From: Simon Davis
Sent: 23 April 2019 11:10
To: Planning Scanning
Subject: FW: FP/64/19/PL Mow Cottage
Attachments: Map .pdf

From: Nigel Locke [REDACTED]
Sent: 18 April 2019 13:29
To: Simon Davis [REDACTED]
Cc: glenn keen [REDACTED]; Wayne Gander [REDACTED]
Subject: Re: FP/64/19/PL Mow Cottage

With regard to the refuse collection the preferred option for the applicants would be as I set out in my Design & Access Statement that they wheel the bins to the collection point in Uppark Way. As shown on the attached OS plan this is a nearer and easier route to wheel the bins than taking them up to the A259 junction. There is also a dog waste bin at the Uppark Way location. I would have thought it would be more convenient for the refuse collectors as they wouldn't have to make a separate stop on the A259.

MOW COTTAGE, WORMS LANE, FELPHAM

SITE PLAN 1:500 @ A3

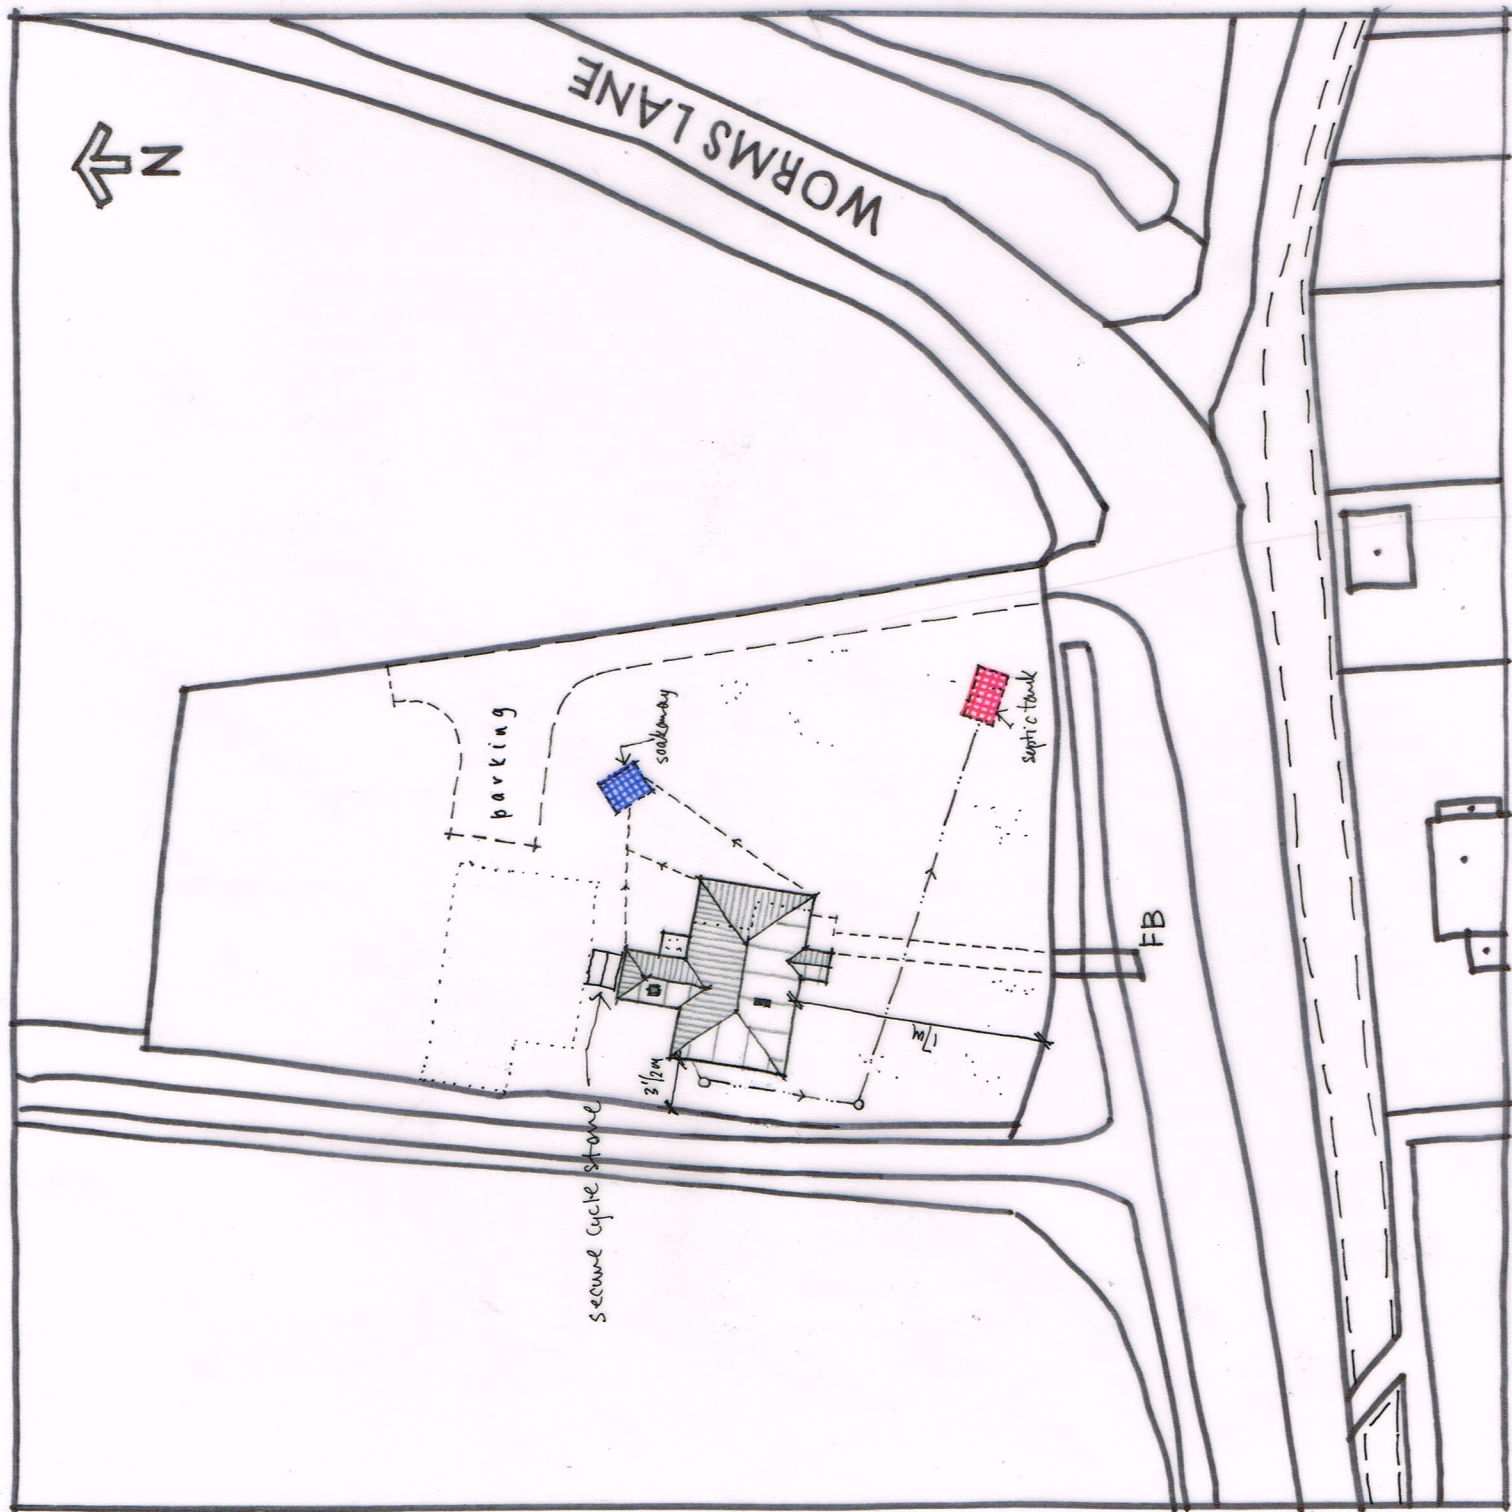
With regard to the council's ecologist's requirement for a 5 metre buffer zone around the construction site for dormice etc. these can easily be achieved off the southern, eastern and northern boundaries. It is however tight on the western boundary where there is just about 5 metres between the proposed side of the new building and the boundary, so I would suggest that we move the building over say 1.5-2 metres to the east so that the buffer zone can easily be achieved. If this acceptable I will get a revised site plan done.

Please note that we have now had Highways comments which are available online and raise no objection. However, regarding refuse collection they state that:

“The plans do not show any refuse and recycling collection arrangements, although Manual for Streets does state that residents should not have to travel over 30m to put bins out and collection vehicles should not have to travel in excess of 25m to collect/deposit bins. This is however a matter of amenity for the Local Planning Authority (LPA) to consider. The applicant is advised to contact the waste disposal authorities to ascertain whether the practise would be acceptable.”

I have today spoken with our Cleansing Operations Manager and he has said that a Council refuse vehicle would not be able to go down Worms Lane to pick up bins and that collection should instead be from the junctions of Worms Lane and the A259 (where a refuse vehicle could pull in briefly).

We will therefore likely add an informative to any decision to alert the applicant to the likely refuse collection arrangements and the need to agree this with the Council.
